**SHORT STOP RESTAURANT
 DEVELOPMENT PLAN MINOR AMENDMENT**
 5819 PALMER PARK BLVD.
 COLORADO SPRINGS, CO. 80915

Subject: Text Box
Page Label: [1] Photometric plan - Short Stop-DP-4
Lock: Unlocked
Author: dsdkendall
Date: 12/17/2018 10:36:25 AM
Color: ■

SD-3

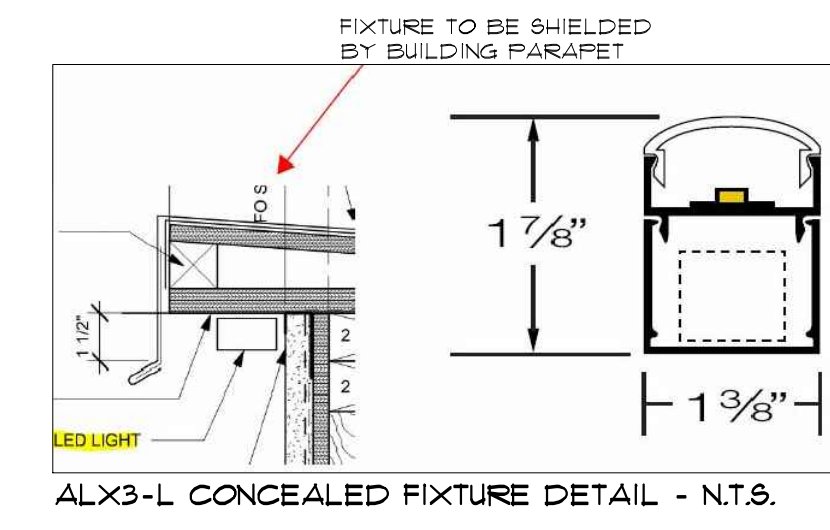
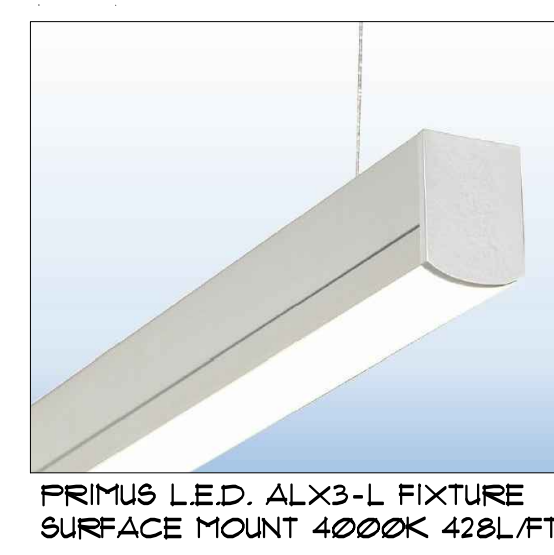
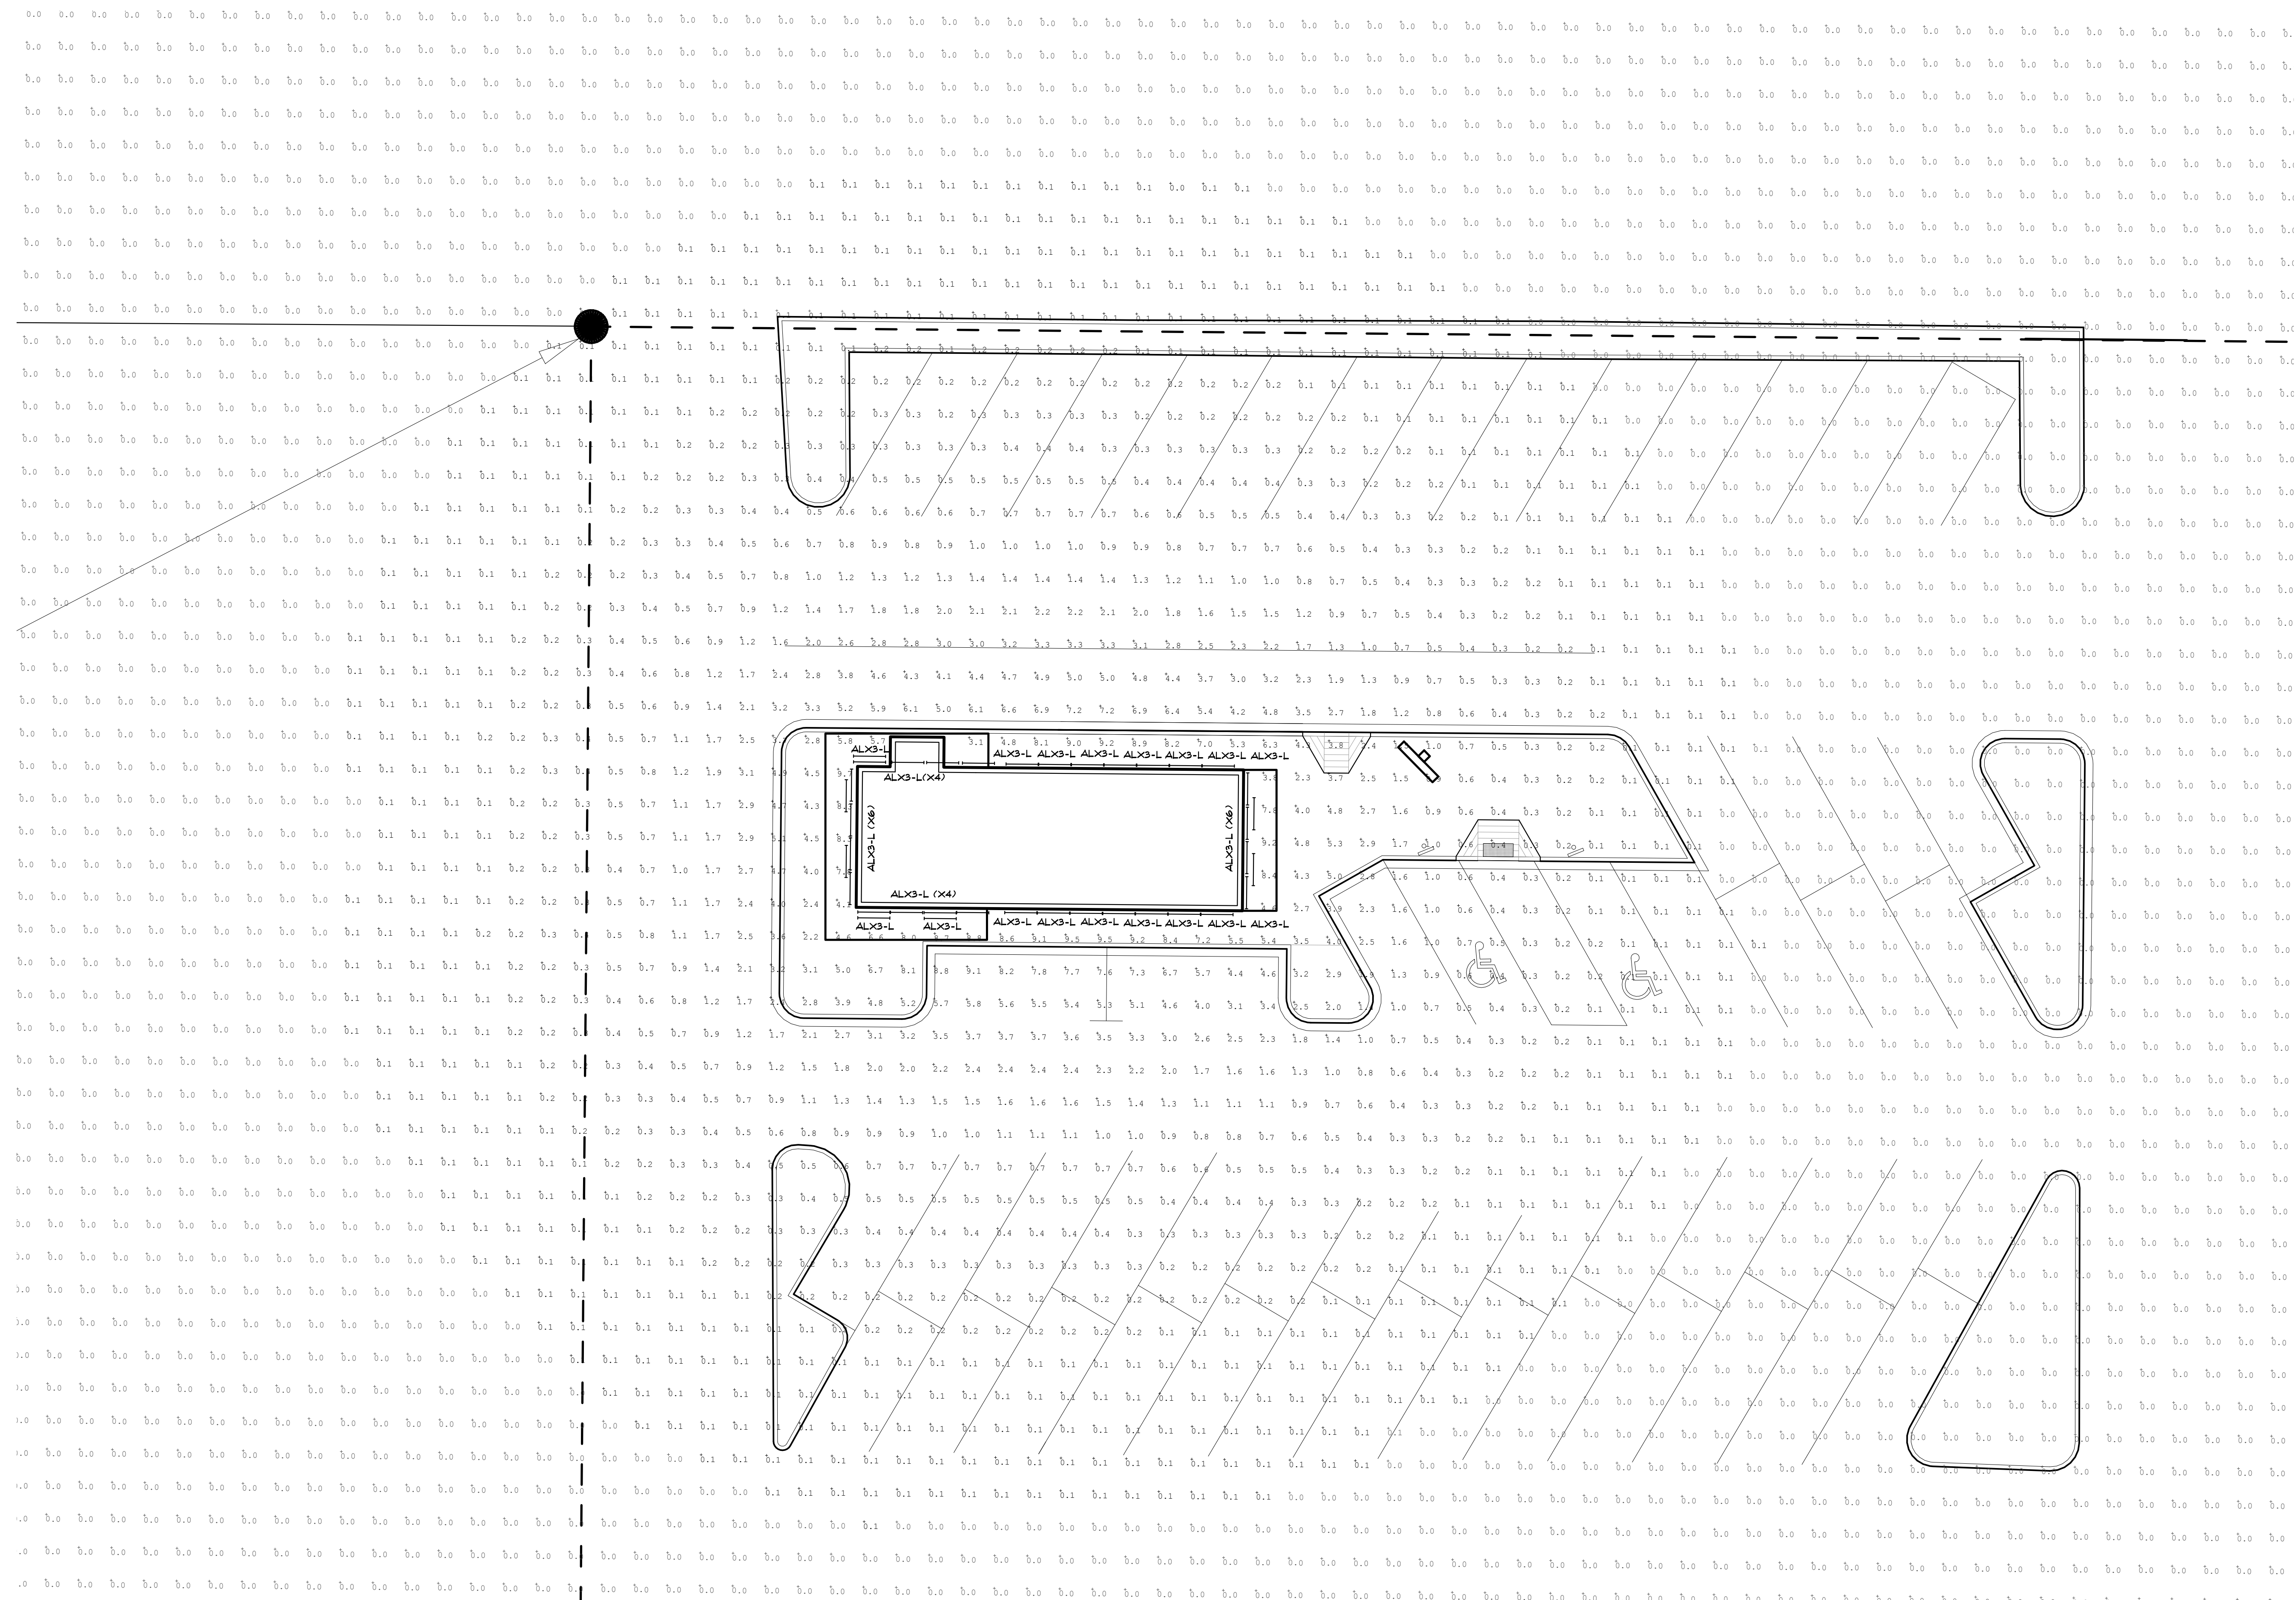
Max amount of foot candles should be 10 unless at a loading and unloading platform, where it can be a maximum of 20 foot candles..

All lighting fixtures need to be shielded or concealed

All lights should be shown in a lighting detail.

6.2.3.B.1 is the section where you can find the lighting standards.
